Re: Planning Application FG/202/18/HH, 26 Beehive Road, Ferring.

I wish to appeal again against the approval of this repeat Planning Application

PROPOSED REAR ELEVATION

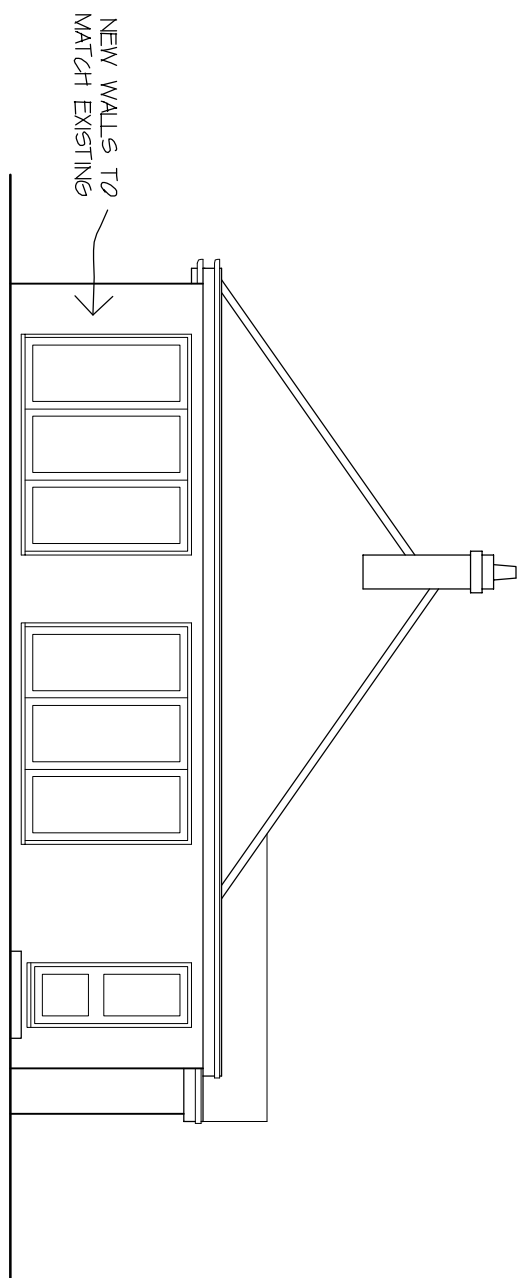
I have today seen a copy of a revised drawing of the proposed alterations to 26 Beehive Lane. This drawing shows that the builders answer to removal of the east side wall and roof is to paint the concrete side panels white. This action will do nothing to correct the overbearing nature of the present construction and will create a maintenance problem for the future, due to there being no adequate access to the wall except through my garden.

PROPOSED ROOF PLAN

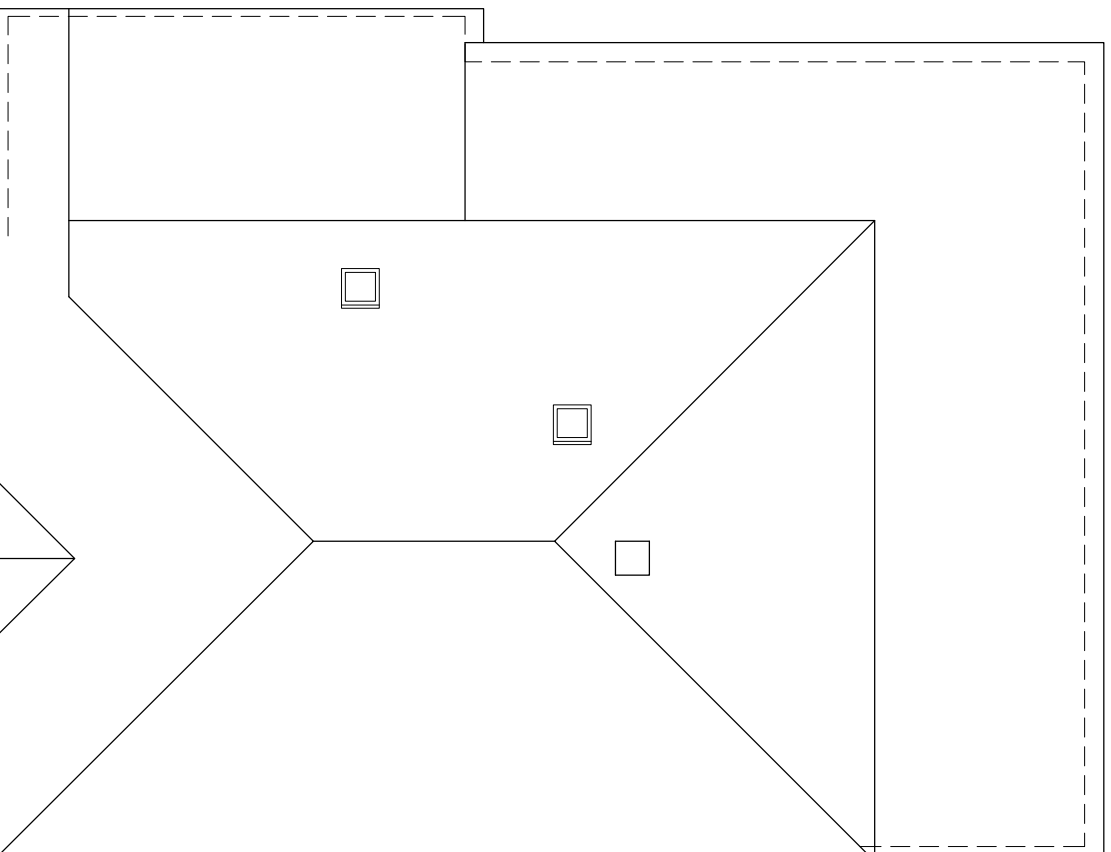
I also note that some openings in the roof have been added for ventilation, these should not allow my property to be overlooked from above.
